Rezoning Transportation Analysis

Petition Number: 2021-130

Date	Description
09-15-21	First Review (BKB)
10-18-21	Second Review (WB)

**RZ1.0**

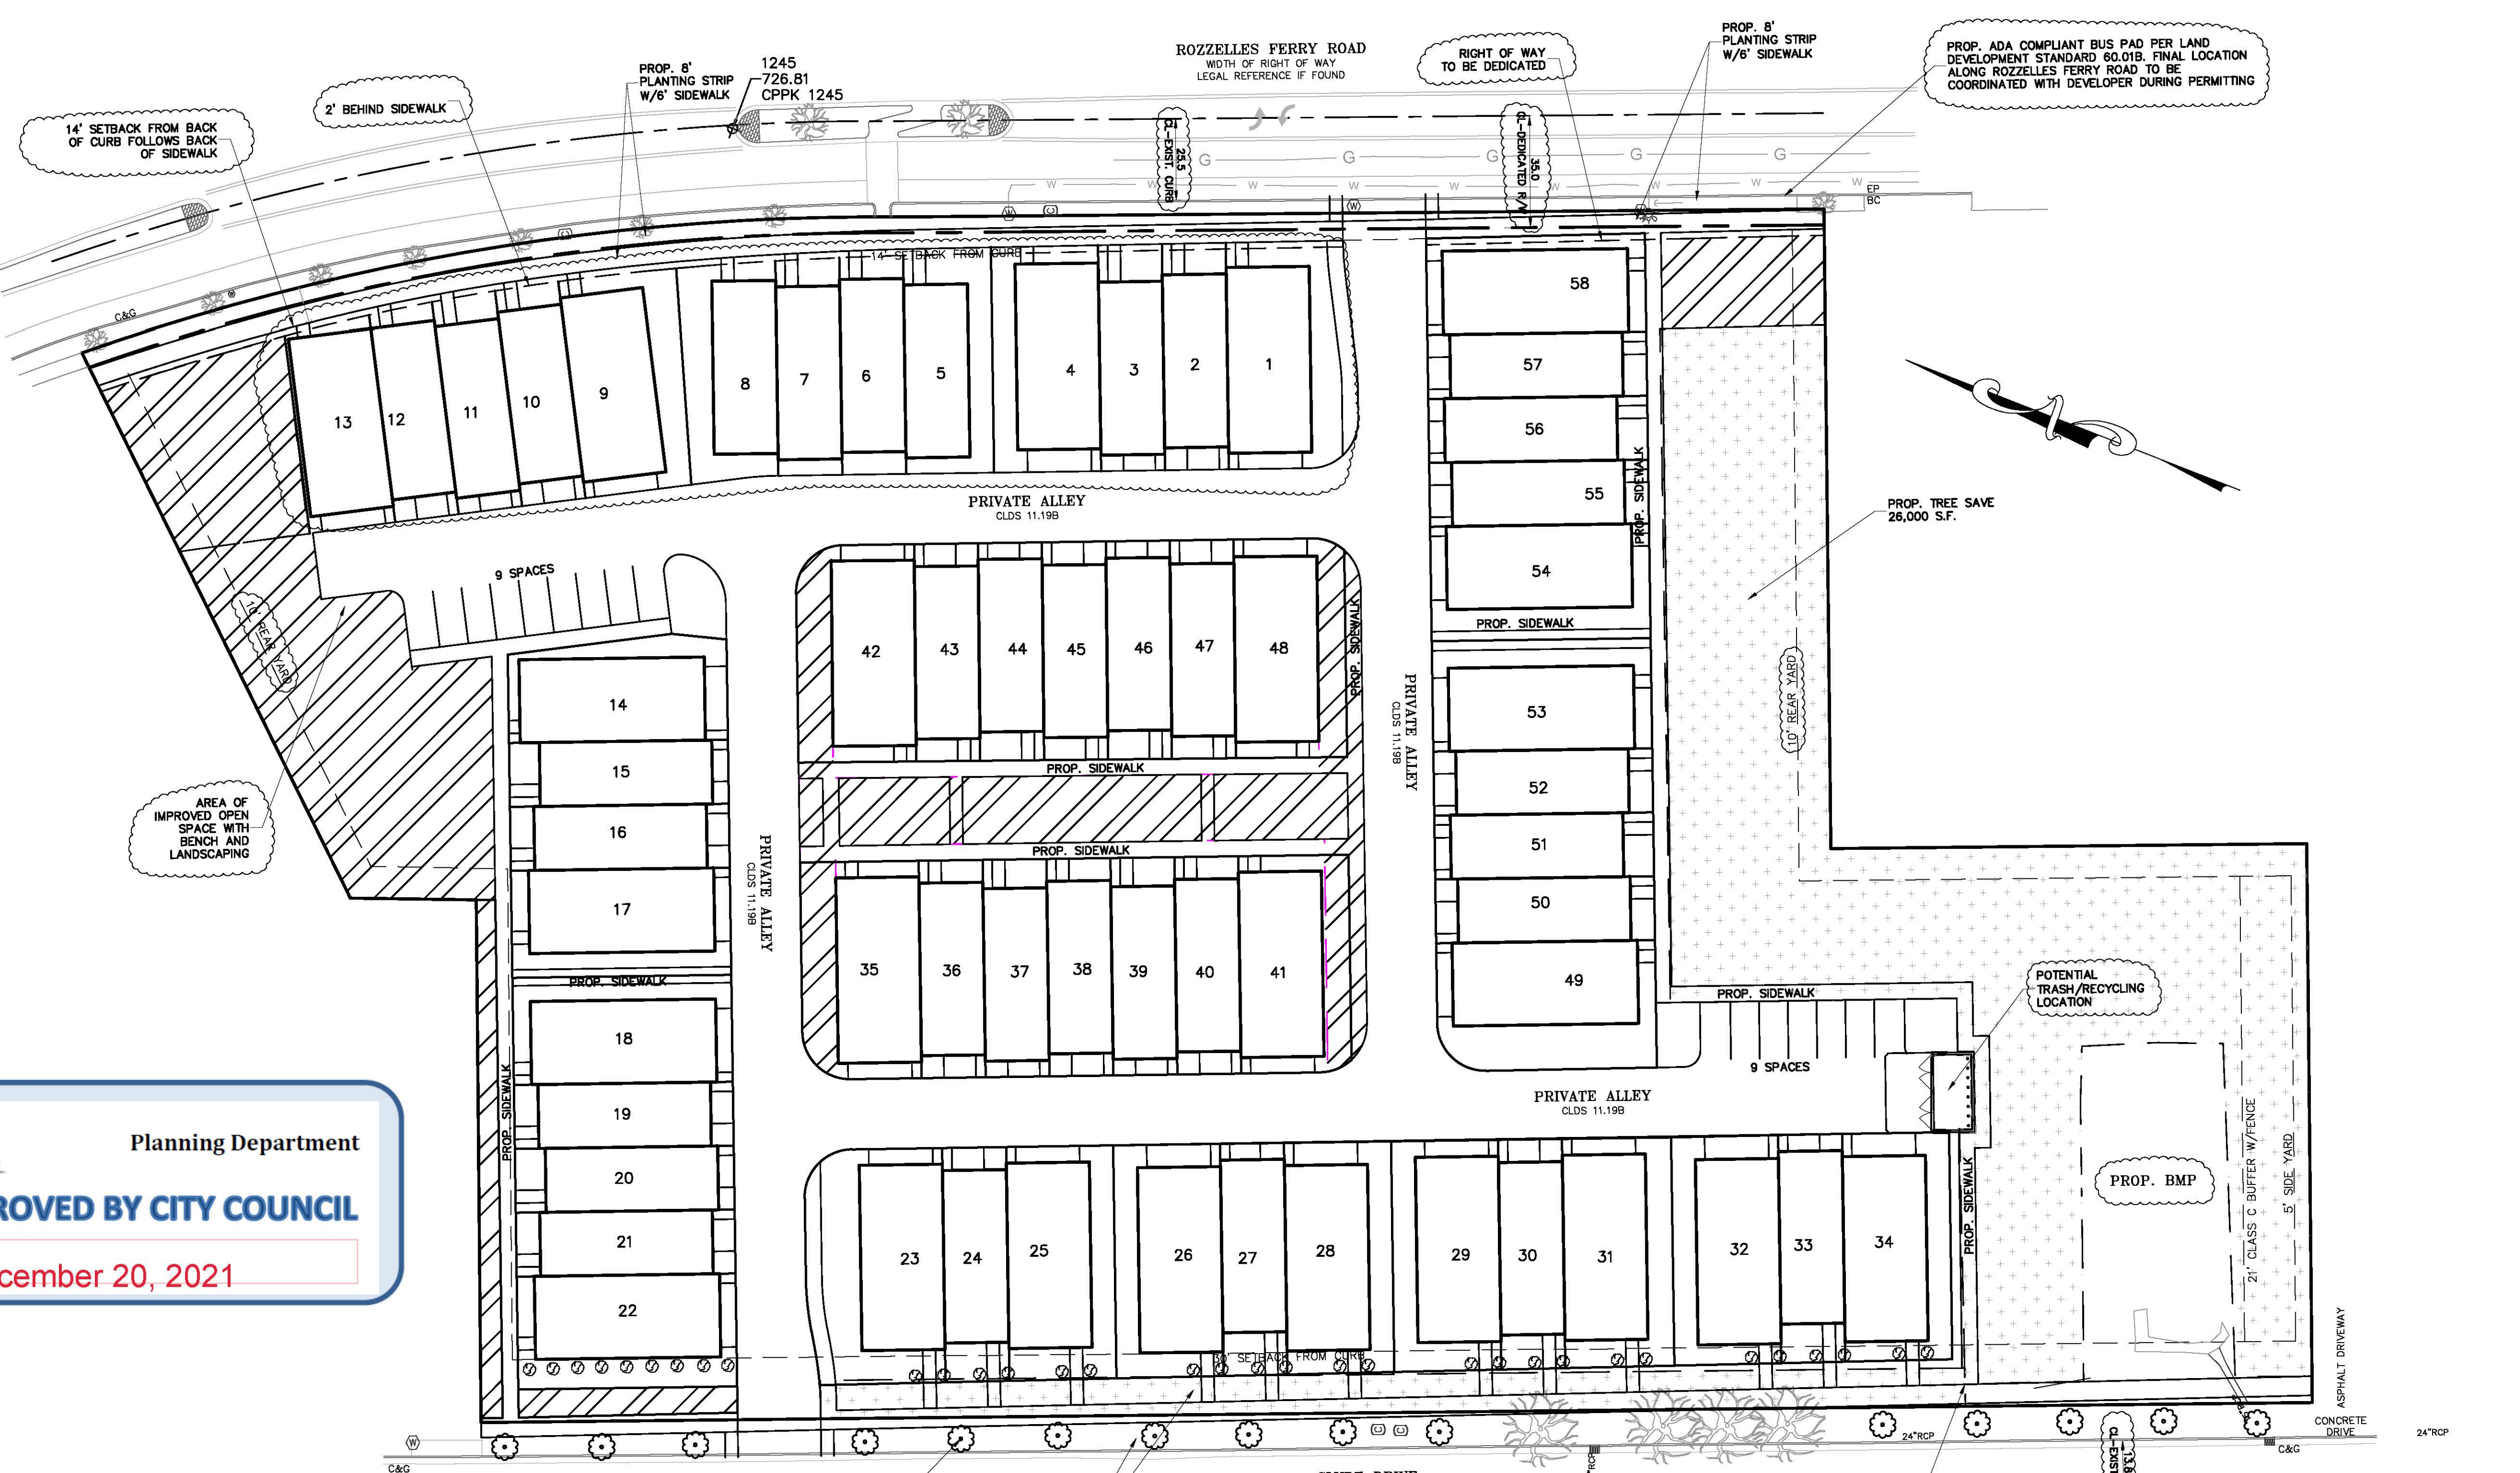
3. Revise site plan and conditional note(s) to commit to dedicate 35-foot right-of-way from the road centerline on Rozzelles Ferry Road. The site plan shall label and dimension the right-of-way from the road centerline.
Comment Clarification (10/18/2021) Future right-of-way to be labeled on the site plan as "Right-of-way to be dedicated".
